**Consultation Response from KC,
Highways Development Management****2025/91370 Land at, Gynn Lane, Honley, Holmfirth, HD9 6LF****REVISED AND ADDITIONAL INFORMATION RECEIVED: Demolition of existing dwelling and erection of 50 dwellings with associated access, infrastructure and associated works****Date Responded: 21/05/2026****Responding Officer: Ryan Kinder****Responding Ref: K3-50/25**

2025/91370 Land at Gynn Lane, Honley
Highway Development Management's (HDM) comments for the above application as follows:

RECCOMENDATION: Objection remains – further information required.

25m FORWARD VISIBILITY

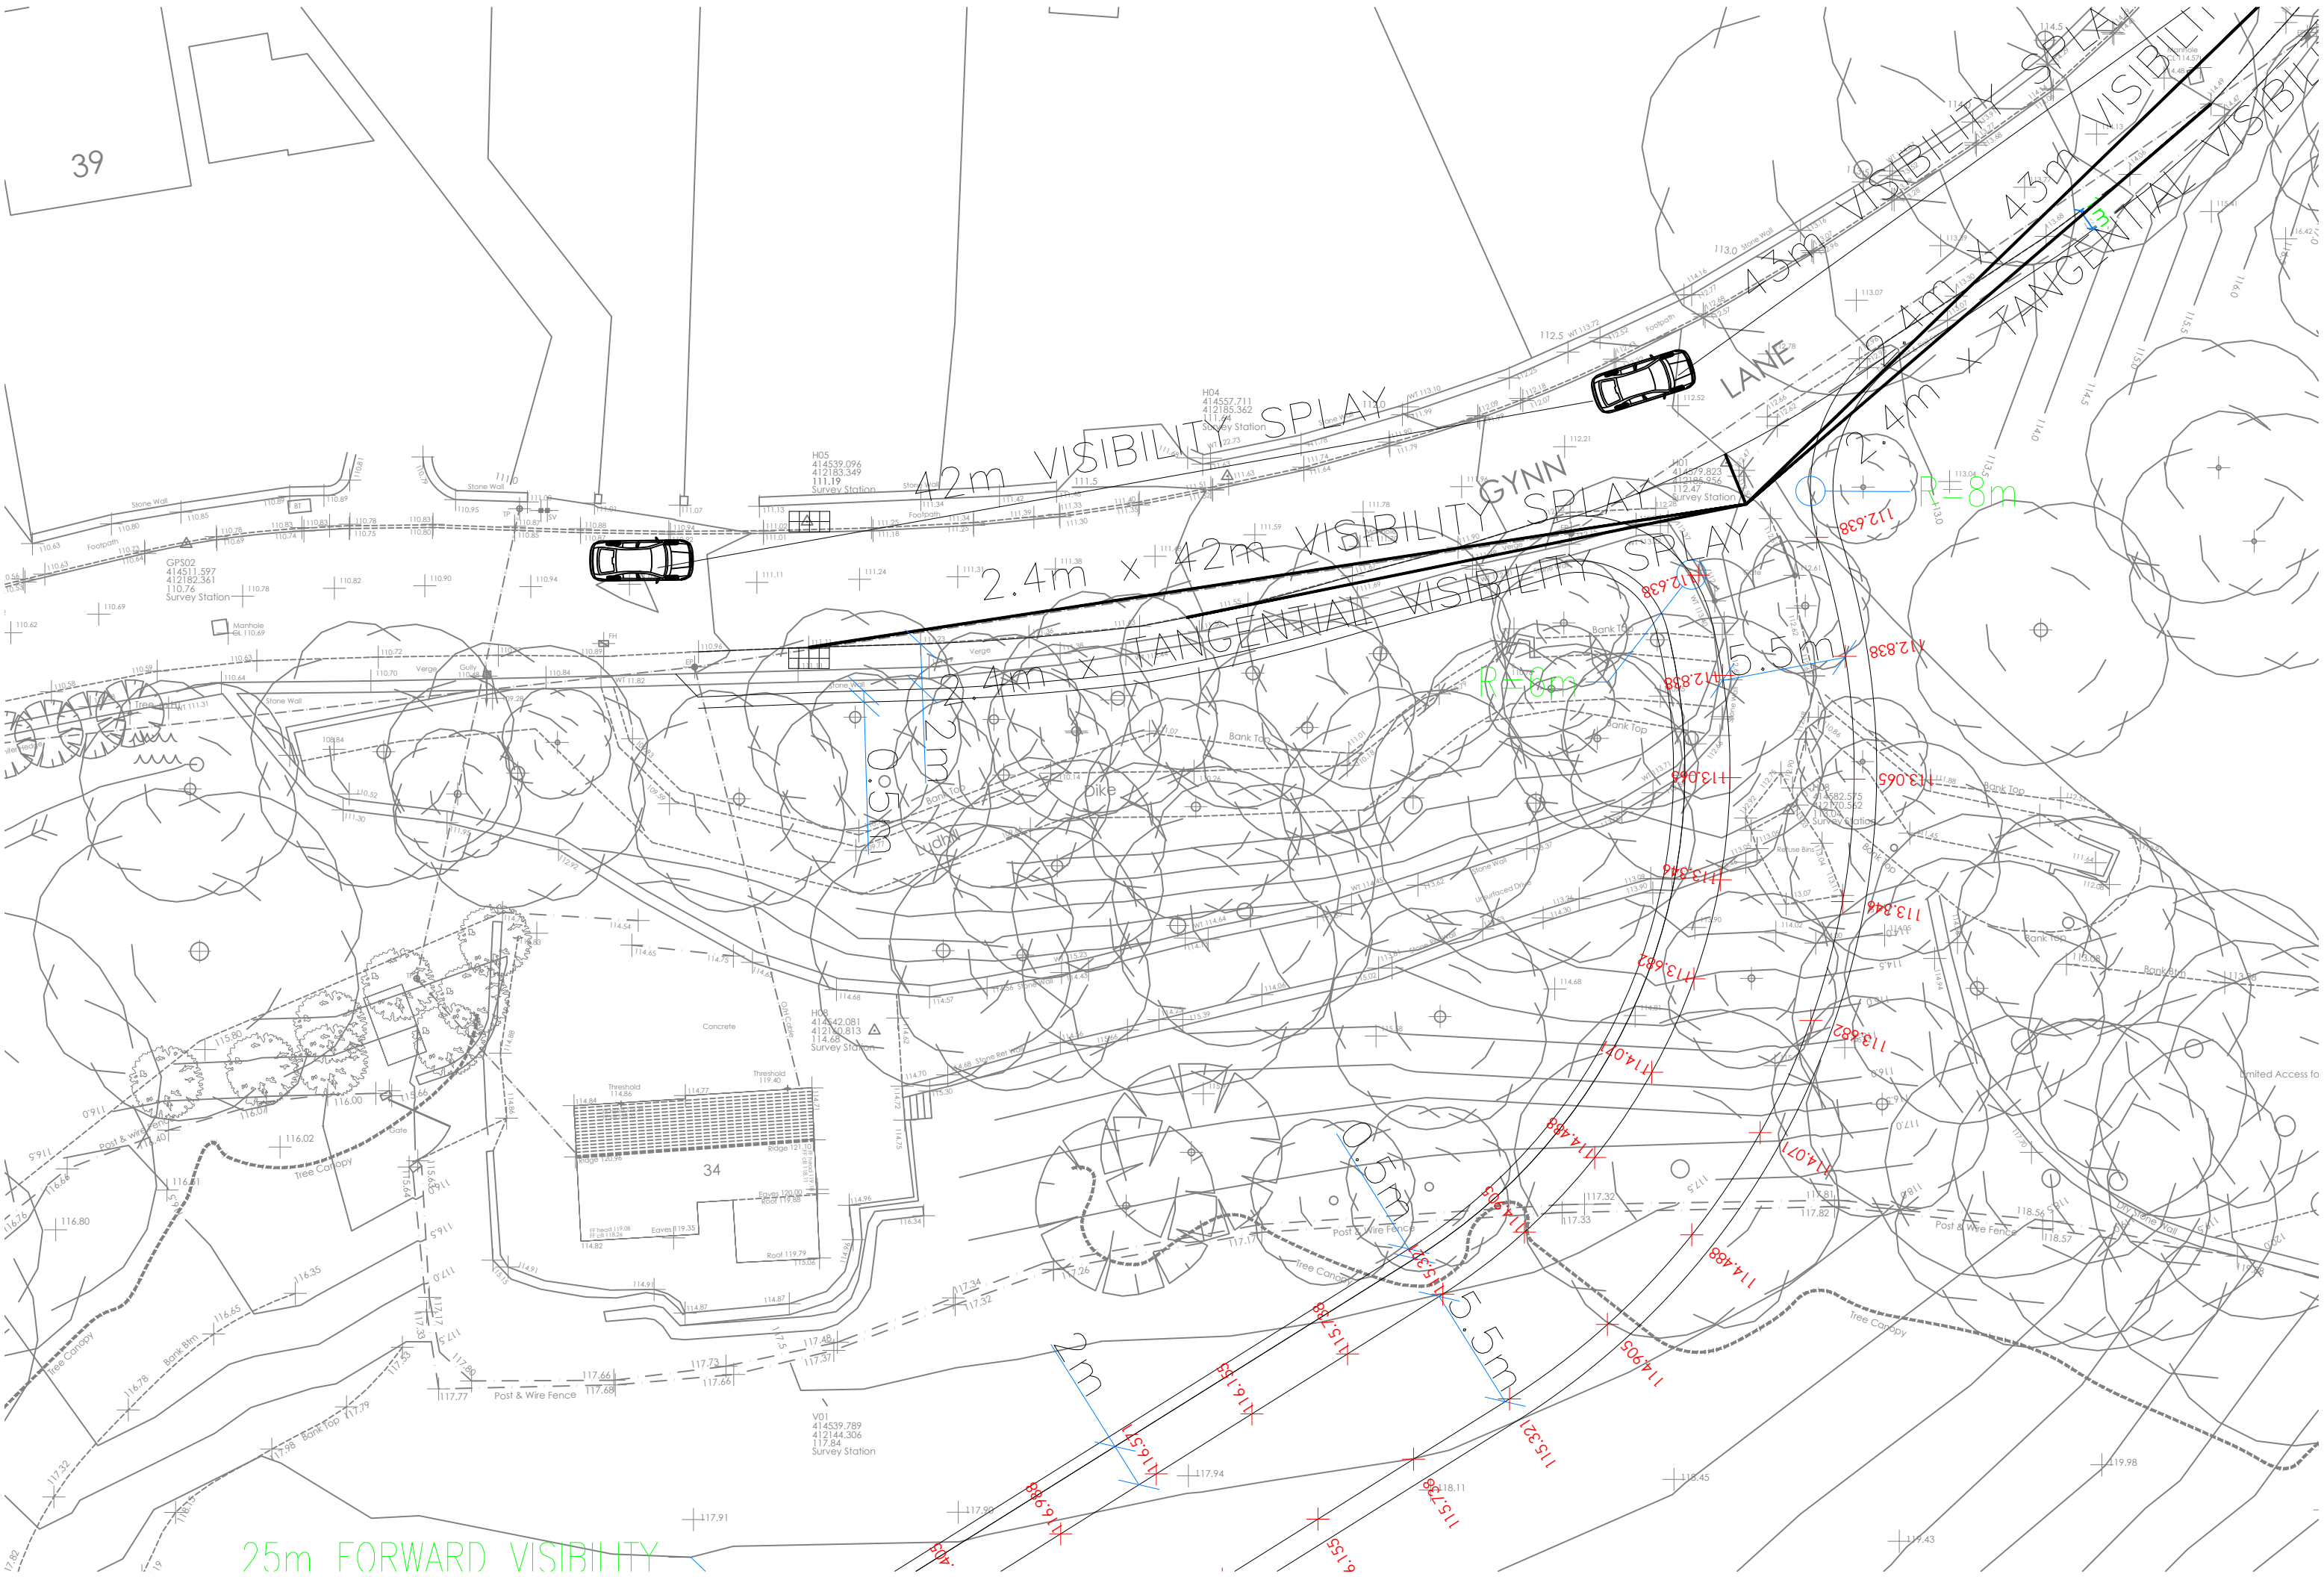
Forward visibility for vehicles waiting to enter the site has been demonstrated (ref 2215108), given this localised carriageway widening at the site access will not be required.
